Date: 7/3/2018
Our reference: DOC18/137697
Contact: Stephen Atkins

Stormwater Management Catherine Hill Bay - MP10_0204 MOD6

I refer to your email of November 21st 2017 regarding a report prepared by ADW Johnson in reference to Responses to Submissions to the above Modification application.

Figure 1: Indicative Stage 7 Stormwater Layout

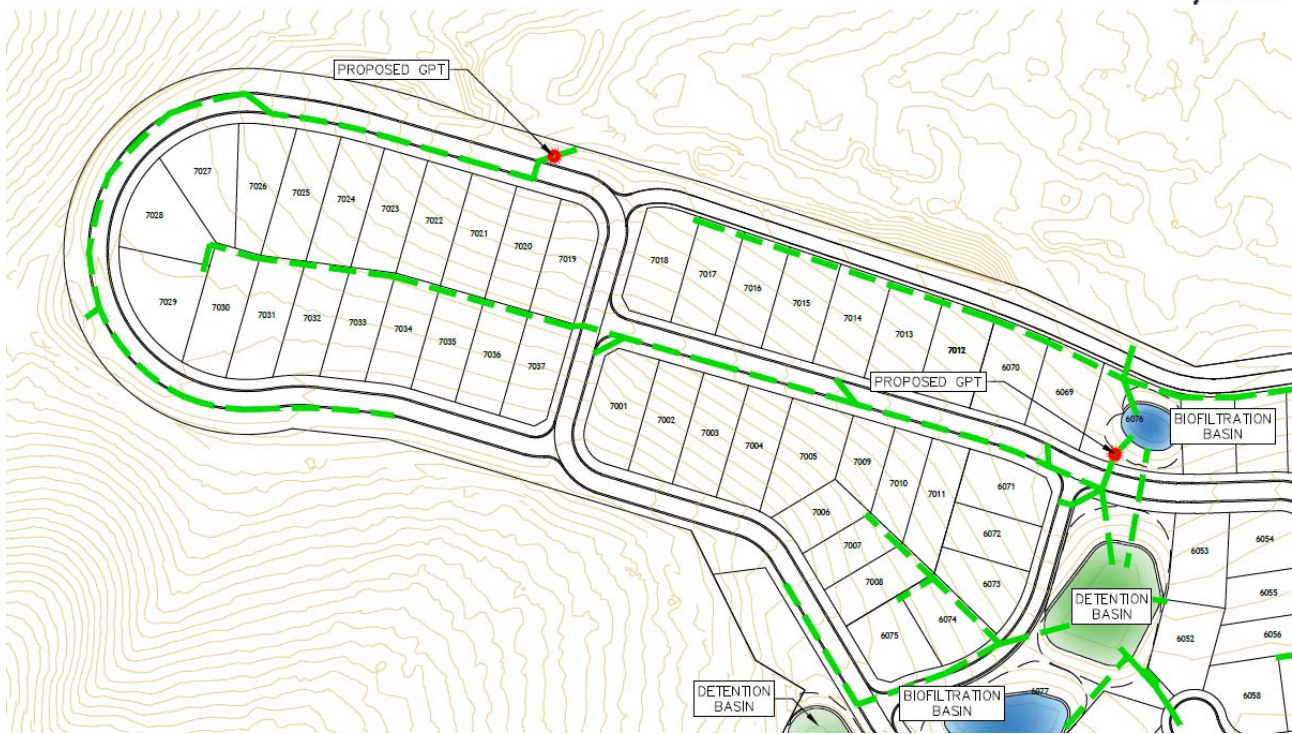
In particular, Figure 1 of the Response to Submissions Report on page 4 makes reference to the location of a stormwater gully over an existing gully line. The report states; *This Gully currently conveys runoff from the subject site as concentrated flows. The outlet locations have been ground trothed to coincide with existing gully lines. Energy dissipation and level spreader structures will be provided to reduce velocities to mitigate potential erosion downstream of the site.*

Our concern is that the gully referred to leads to a small lagoon that contains a high level of unconsolidated sediment build up in the lower section. The result of this over time has effectively reduced the outflow capacity of the lagoon, and any additional sediment entering the lagoon will further decrease the movement of water particularly during periods of heavy rain, which may impact on adjoining properties.

Given that a portion of stormwater in Stage 7 cannot be discharged through the stormwater quality controls in Stage 6 and therefore will be discharged via a Gross Pollutant trap, support is provided for the recommendation from Lake Macquarie City Council for additional stormwater detention and water quality controls.
